**Sunflower Landscapes
Variance of Use
Letter of Intent**

March 31, 2026

PDC File No. VA265

PRELIMINARY LANDSCAPE PLAN

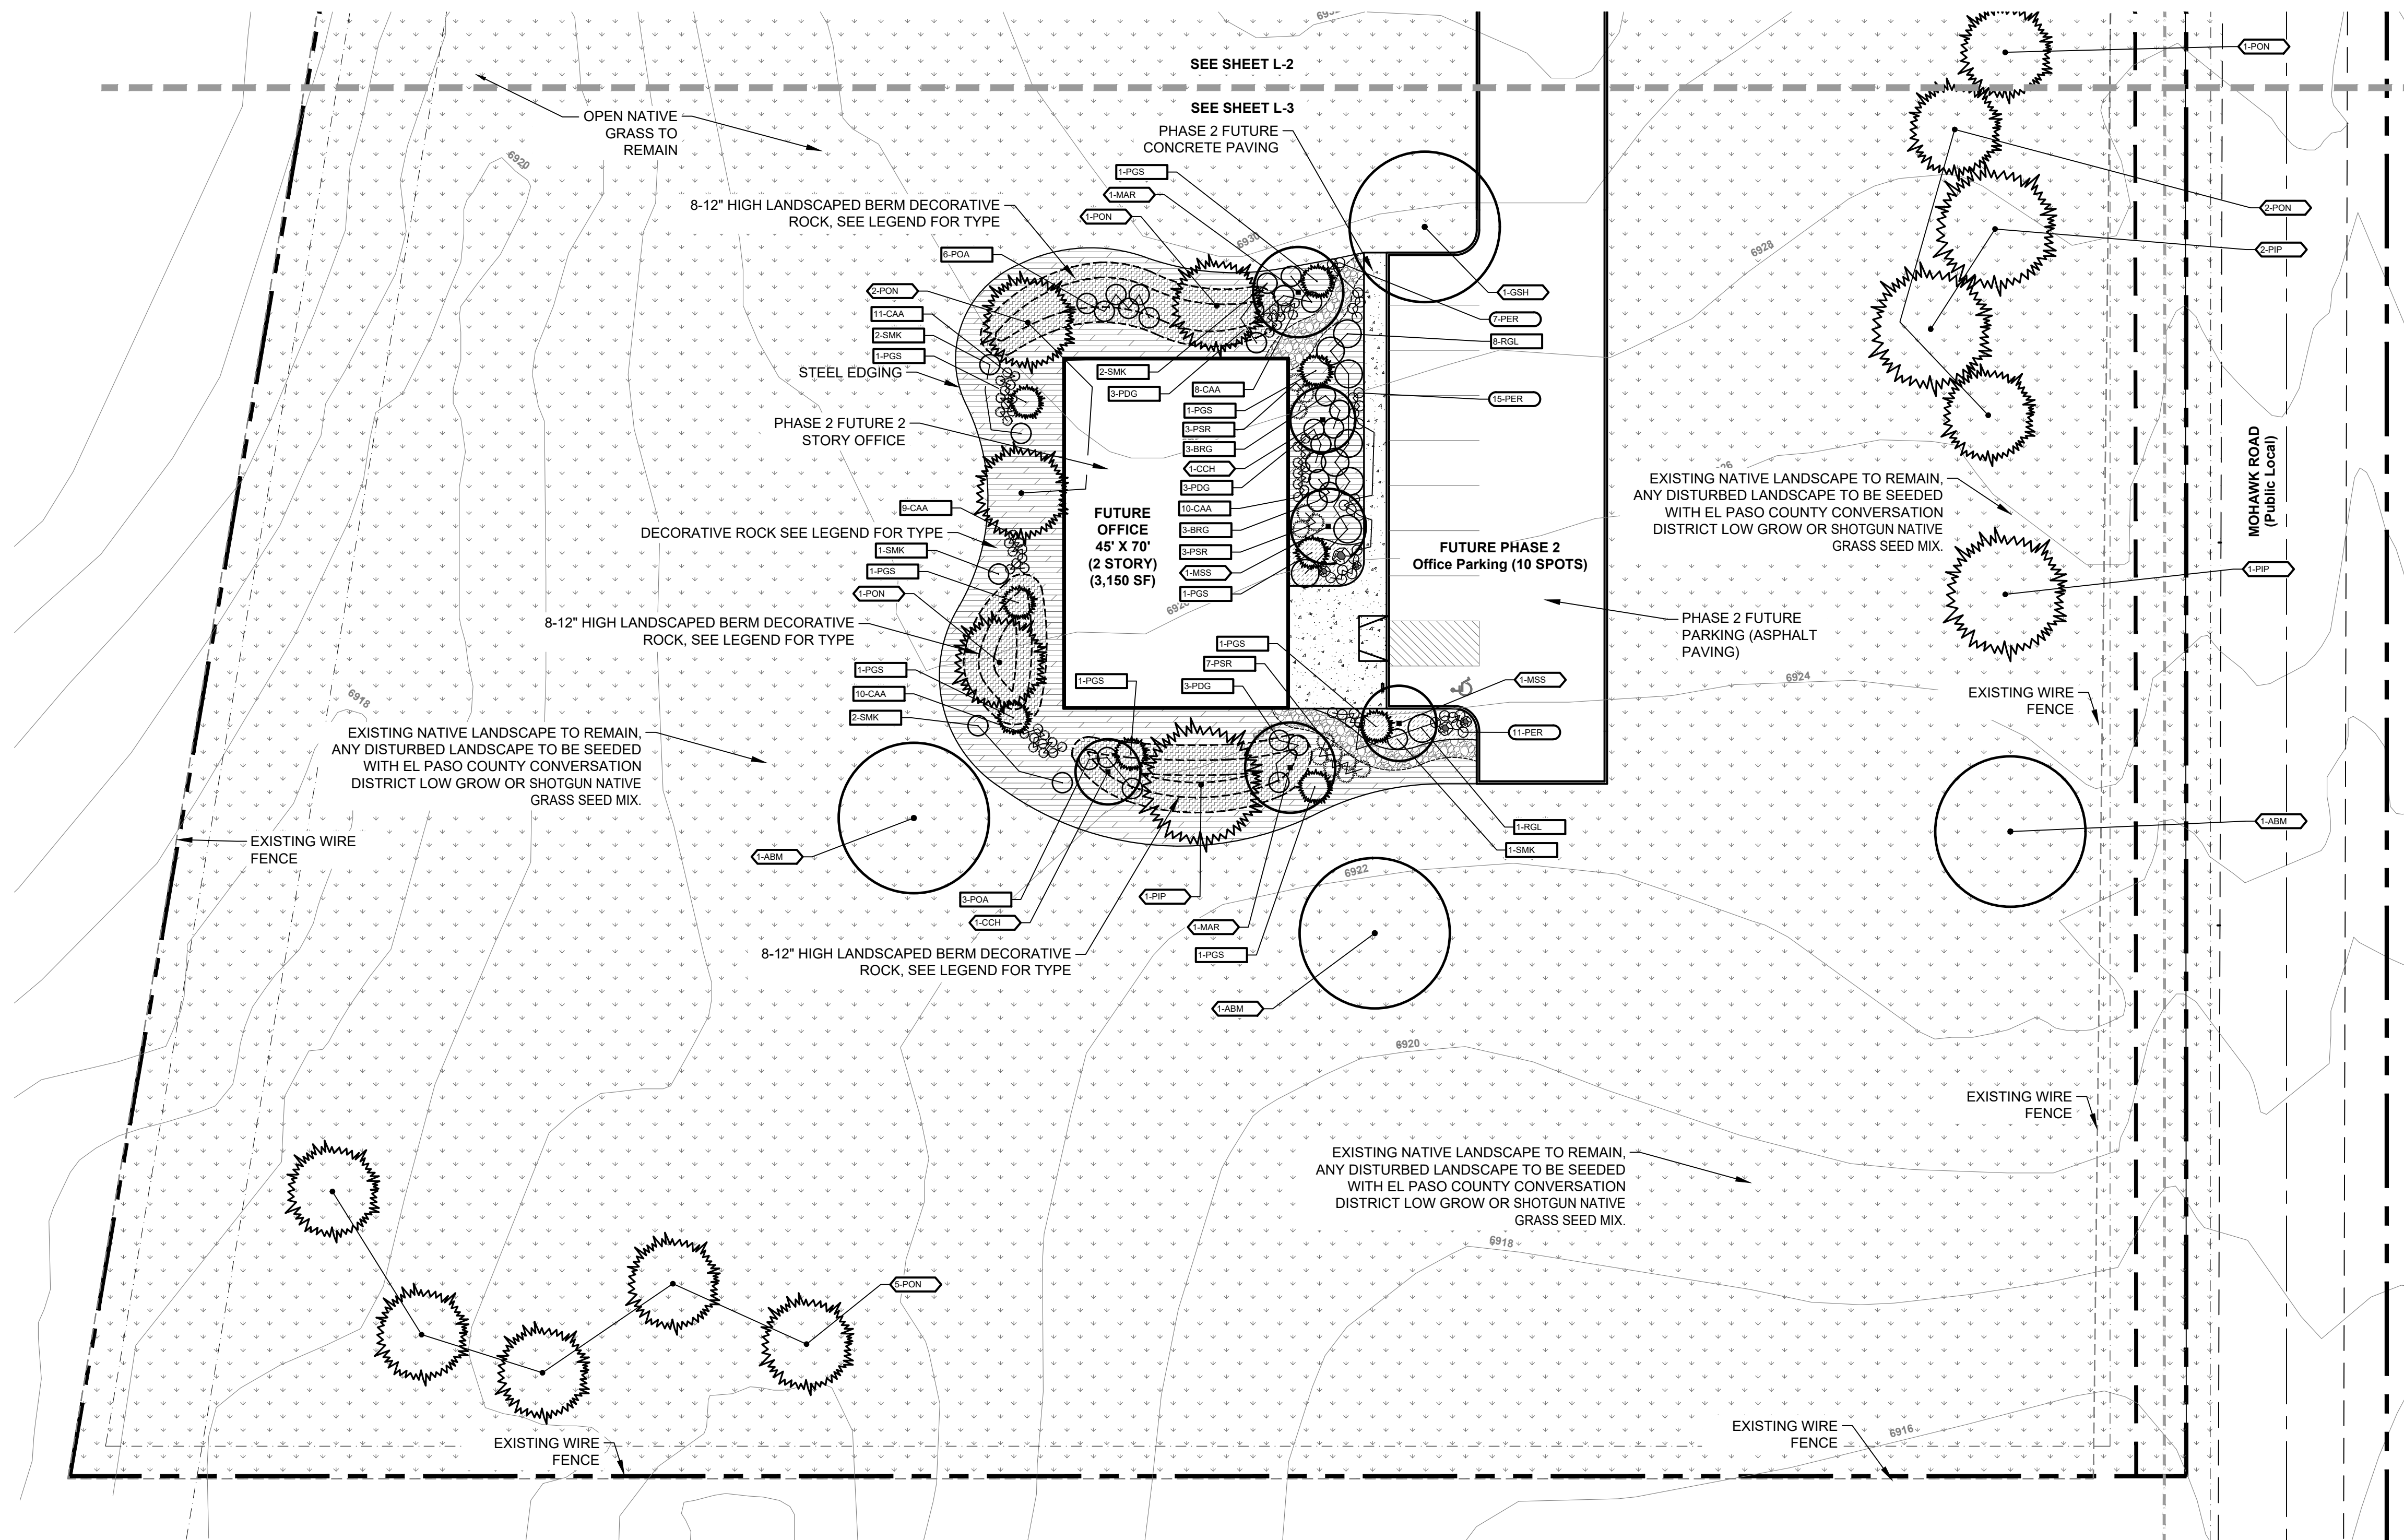
Major unresolved issue: The proposed parking is insufficient and does not demonstrate compliance with the Land Development Code. Although the applicant indicates employees will carpool, this is voluntary and cannot be relied upon to satisfy required parking standards. Please revise the parking layout, number of staff, or otherwise demonstrate compliance with the Code.
